Date: 30 October 2024

Application by Gloucestershire County Council for an Order Granting Development Consent for the M5 Junction 10 Improvements Scheme: TR010063

Submission made by the Joint Councils pursuant to Deadline 7 (D7) of the Examination of the M5 Junction 10 Improvements Scheme

Project Title		M5 Junction 10 Improvements Scheme	
Drawing Title		FIGURE 10-3 AGRICULTURAL LAND CLASSIFICATION	
Drawing Number		GCCM5J10 - ATK - EGT ZZ - GS - GI - 000001	
Original Size: A3	Scale: 1:15,000	Project Ref: 5214106	Sheet: 1 of 1 Rev: P02

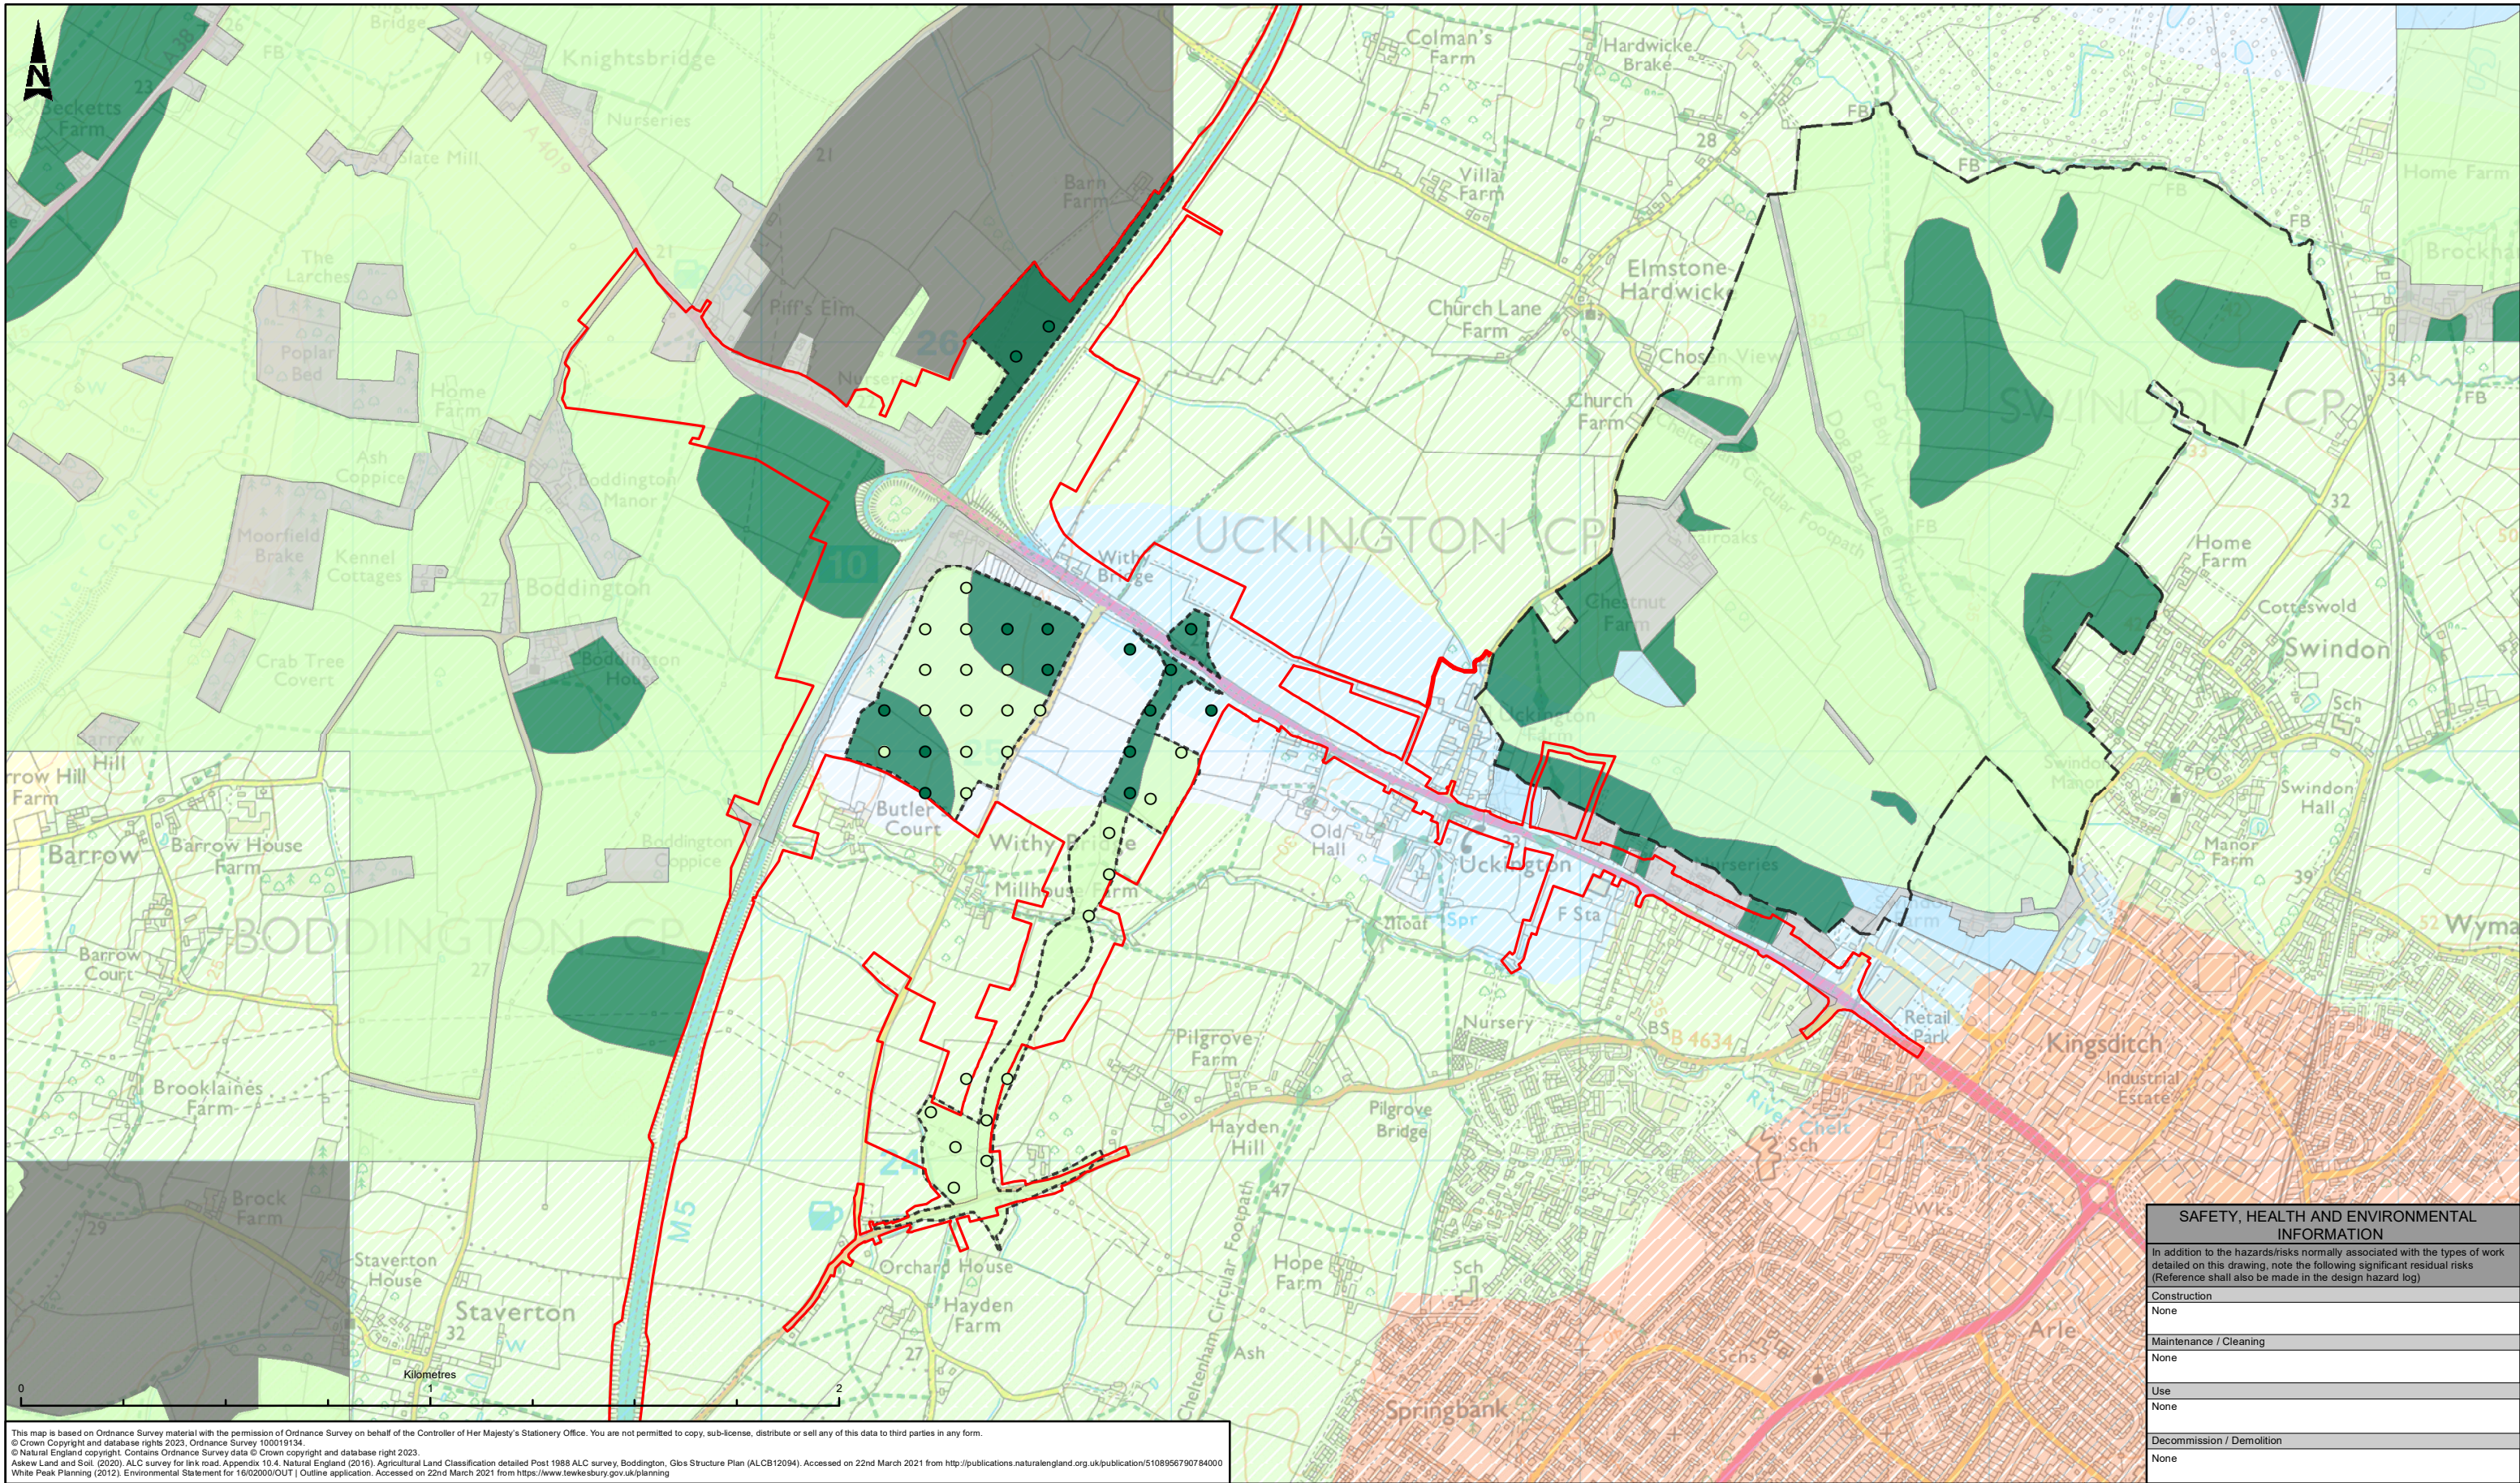
The Joint Councils have reviewed [REP5-007]. The only chapter update is the production of the additional figure - no changes / updates to the chapter text by the looks of it. Figure 10.3a is helpful to show the context of the scheme and surroundings with respect to BMV land and loss of BMV land through the scheme. The figure also addresses one of the Joint Councils' previous comments about the agricultural land classification associated with the Elms Park Development.
